# MONA OFFSHORE WIND PROJECT

## Annex 3.4 to the Applicant's response to NRW's Relevant Representation at the Procedural Deadline

### Applicant's Response to Relevant Representation from Natural Resources Wales (NRW): RR-011.98 to RR-011.104

Document Number: MOCNS-J3303-RPS-10223

Figure 56: Viewpoint 28: Penmon Point, Isle of Anglesey AONB (90° Cumulative Wirelines - Views North

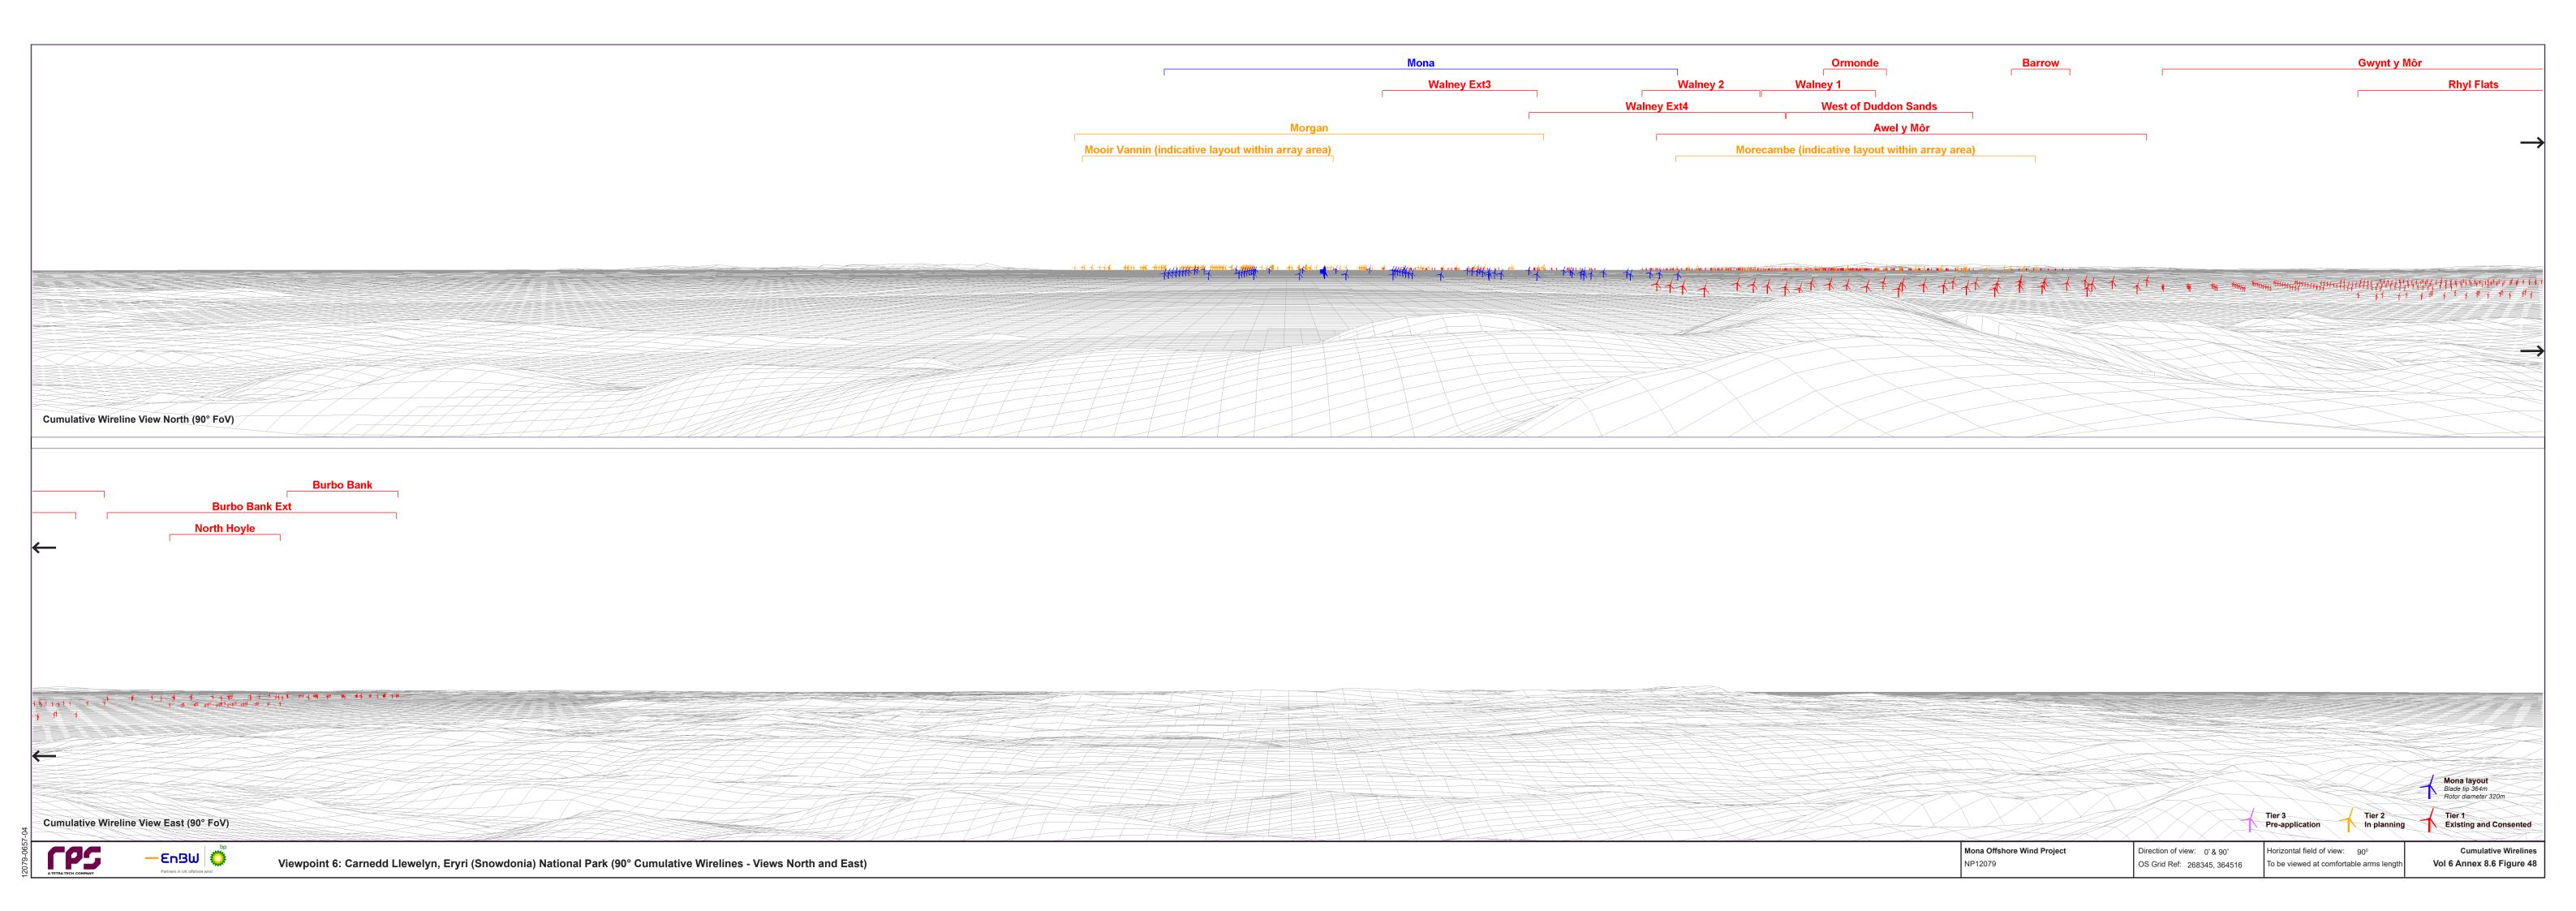
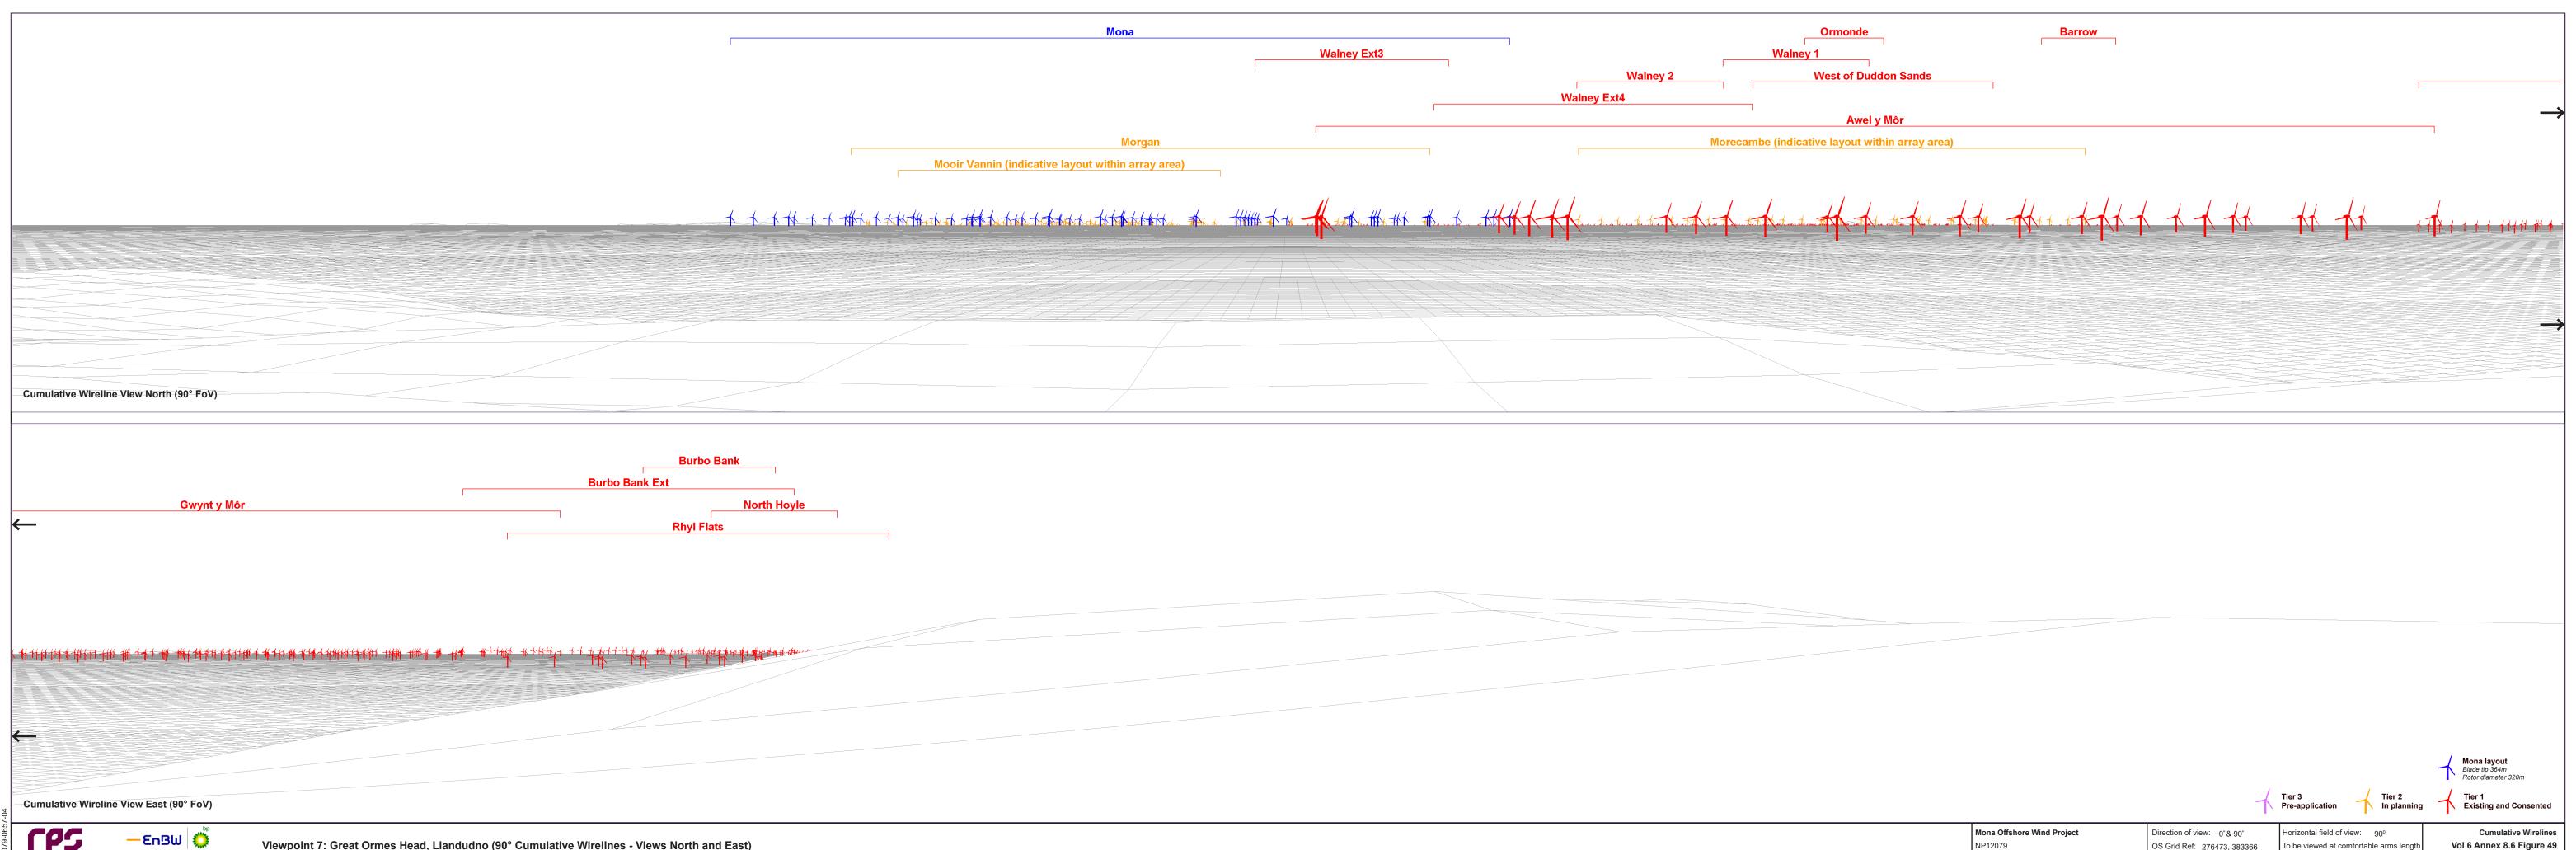
*We advise that cumulative wireline visualisations – depicting the proposed turbines in combination with schemes scoped into the cumulative SLVIA - have only been prepared from a select number of viewpoints (5 in total across all three SDLs). This means at other viewpoints, where the nature of the view and impact would be different, no visualisation is provided. Given the nature of the proposal, the sensitivity of the receptors being assessed, and the conclusions of the SLVIA with regard to these receptors, we advise cumulative visualisations should be provided from all relevant viewpoints within the SDLs. We also consider cumulative visualisations showing the proposed substation and other Tier 1 developments (including the Awel y Môr substation) should be provided.*

- 1.2.4.7 Cumulative wirelines from representative viewpoints within nationally designated landscapes in Wales have been prepared from viewpoints 6 Carnedd Llewelyn, Eryri National Park (Figure 48), Viewpoint 10, Graig Fawr, Clwydian Range and Dee Valley (Figure 50), Viewpoint 11, Moel y Parc, Clwydian Range and Dee Valley (Figure 51) and viewpoint 28, Penmon Point, Isle of Anglesey (Figure 56). These are presented in Volume 6, Annex 8.6: Seascape Visualisations Part 7 (APP-112).

- 1.2.4.9 Cumulative visualisations showing the Mona Offshore Wind Project alongside Tier 1 offshore projects are presented in - Volume 6, Annex 8.6: Seascape visualisations Part 7 (Figures 47- 56) (APP112). Cumulative visualisations showing the proposed onshore substation and other Tier 1 developments (including the Awel y Môr substation) from representative viewpoints within Clwydian Range and Dee Valley NL have not been generated, in part as the nature of the Awel y Môr onshore substation is not known. However, the effects from the proposed onshore substation are anticipated to be limited as outlined in Volume 3, Chapter 6: Landscape and visual resources (APP-069), due to:
